**From:** Martyn White  
**Sent:** 11 December 2018 17:21  
**To:** Planning.Responses  
**Cc:** Amber Willard  
**Subject:** AW/275/18/HH

**AW/275/18/HH**

The application is seeking permission for a development of: first floor side extension, loft conversion with rear dormer, rear canopy, and extension to detached garage

SECTION A-A

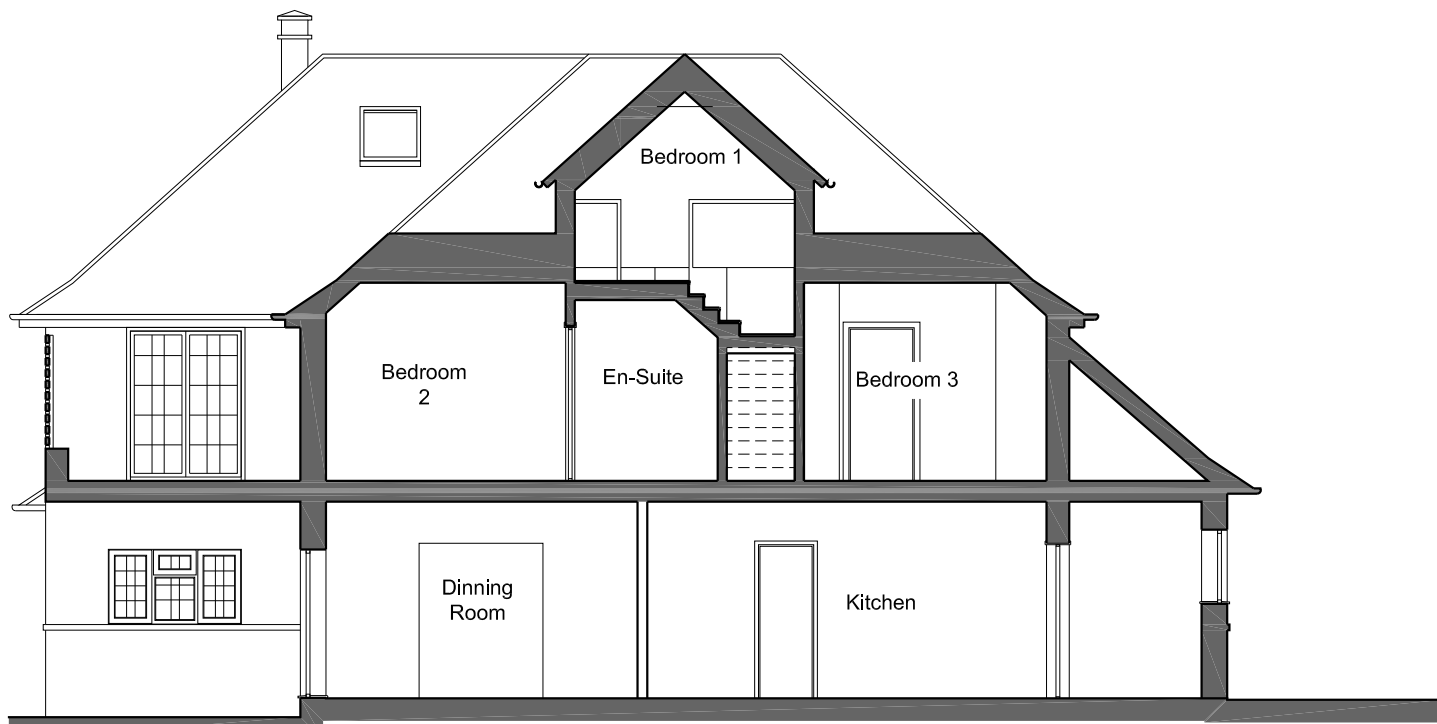
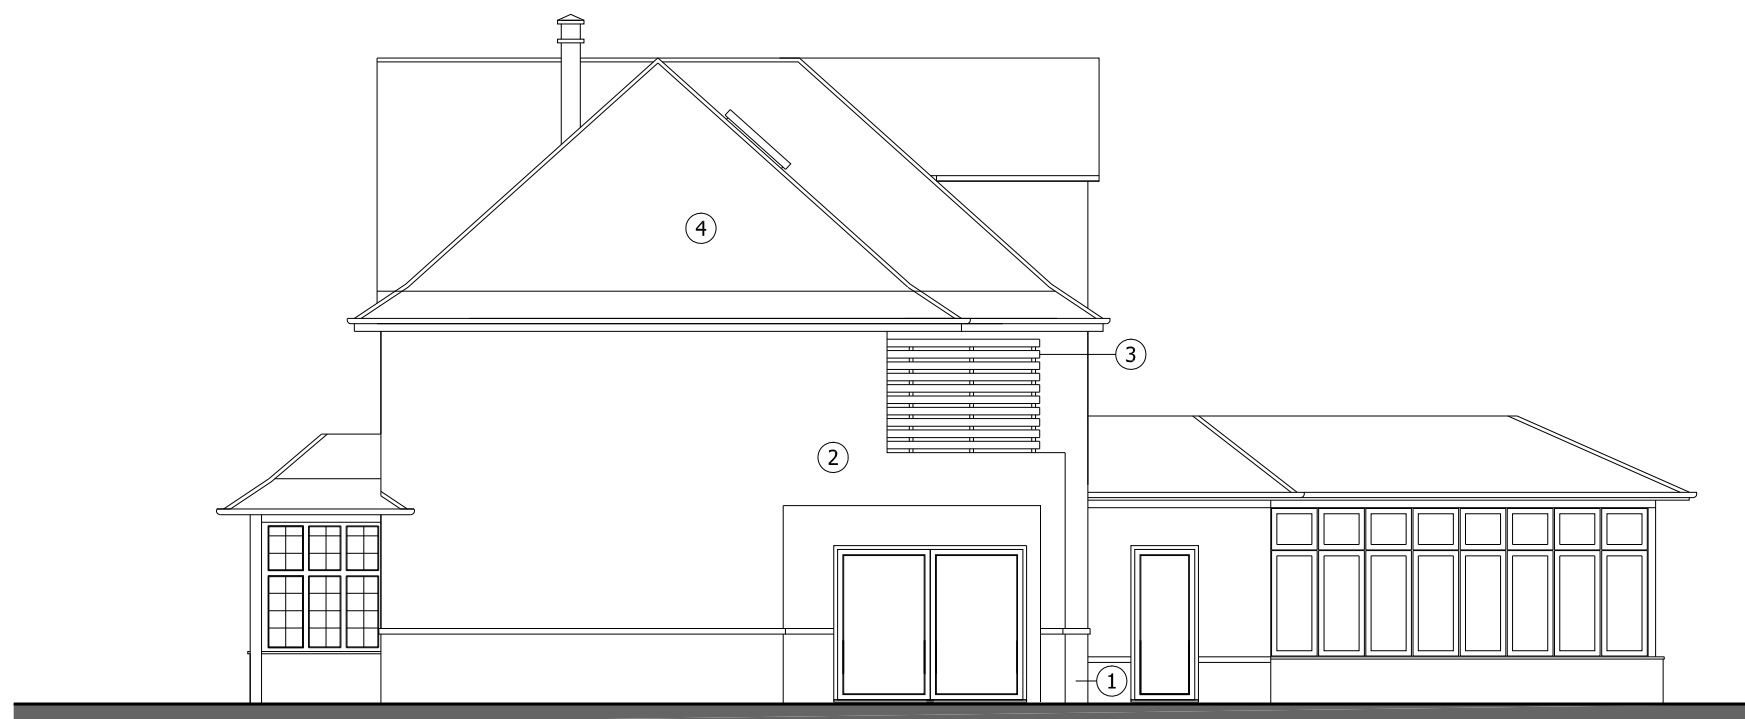
The application amounts to a substantial amount of work to the property with the side extension potentially having the greatest impact upon the character of the area, as it is visible from the public realm. Such an extension appears to be designed to reflect the character of the host dwelling, and subject to issues related to materials can be supported.

The rear dormer is substantial, occupying approximately ¼ of the proposed rear elevation. As a consequence, it appears to dominate the property. The size of the dormer is queried; does it need to be this size, or is there potential to reduce its size, and therefore its impact?

The success of the works will depend upon the quality of the material to be used. If minded to approve the application, materials should match existing. The rooflights should be of conservation standard.

Drawing Title:
EXISTING GARAGE PLANS & ELEVATIONS
PROPOSED SINGLE STORY EXTENSION TO
EXISTING GARAGE

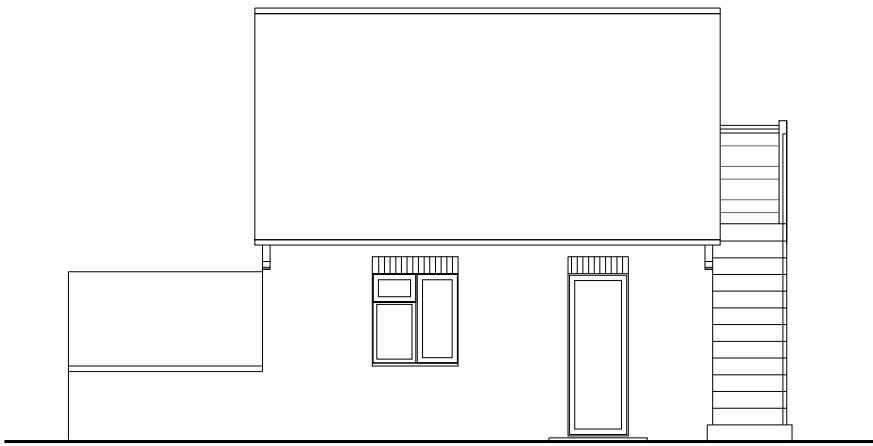
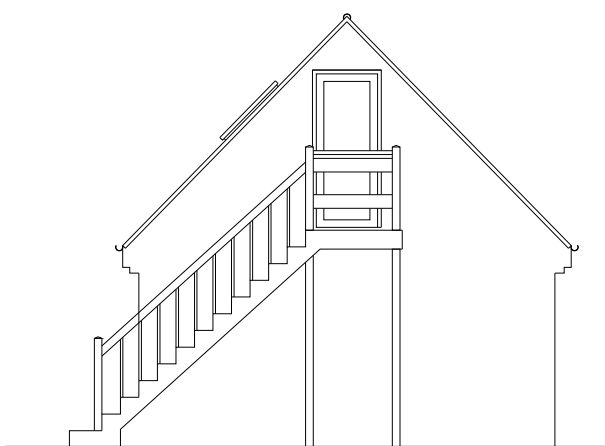
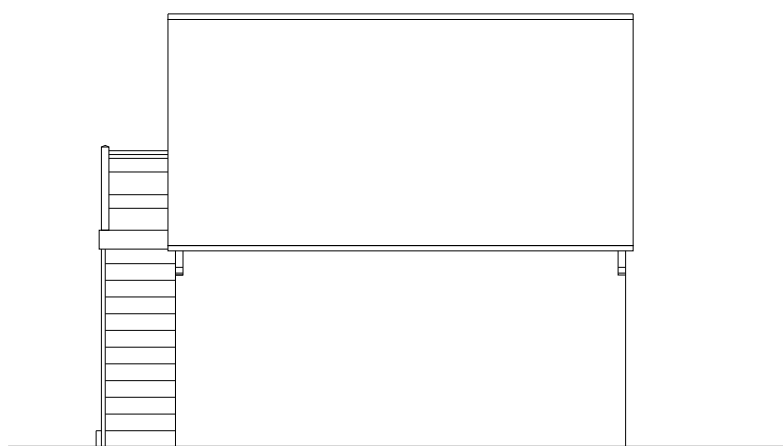
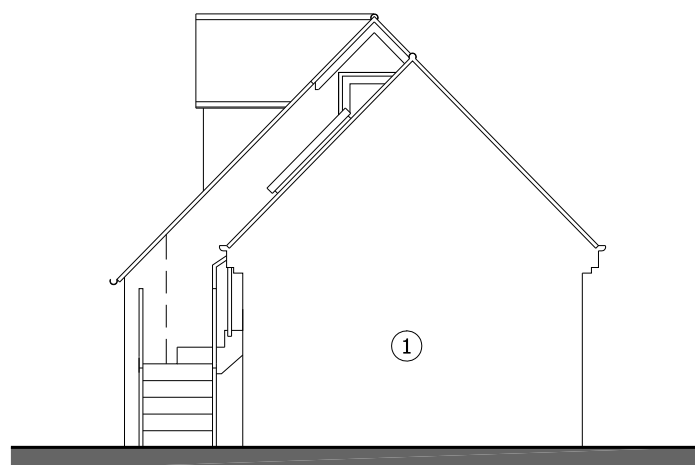
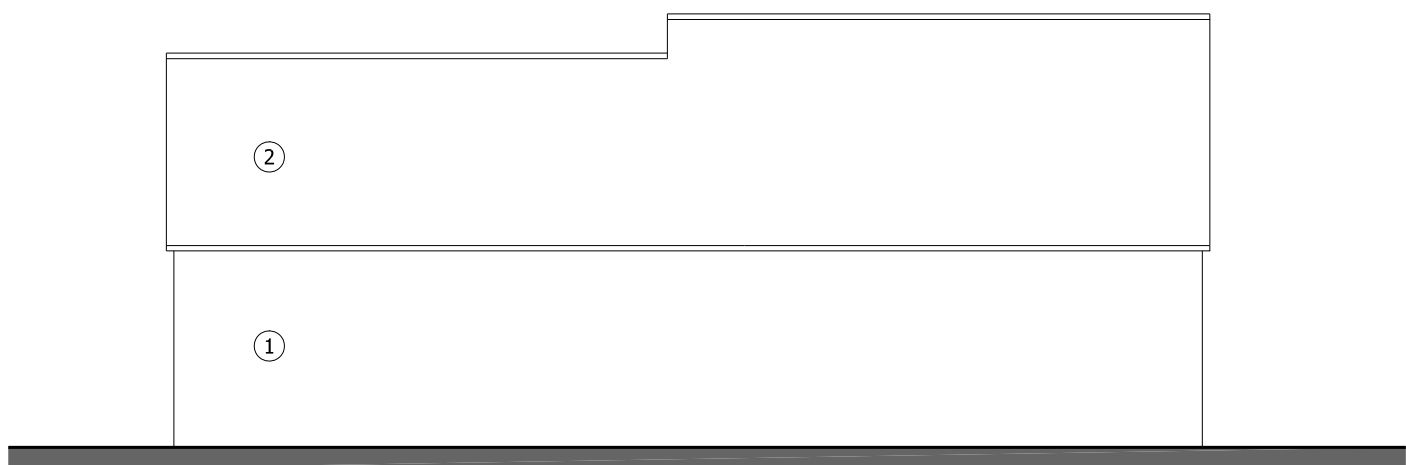
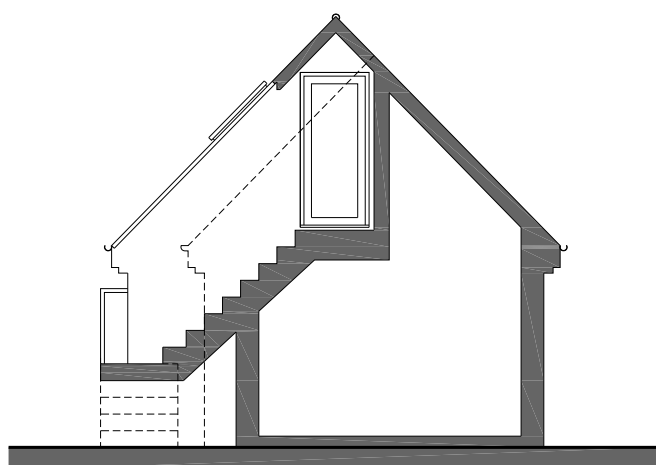
The rear extension to the existing garage will have a neutral impact upon the character of the building.
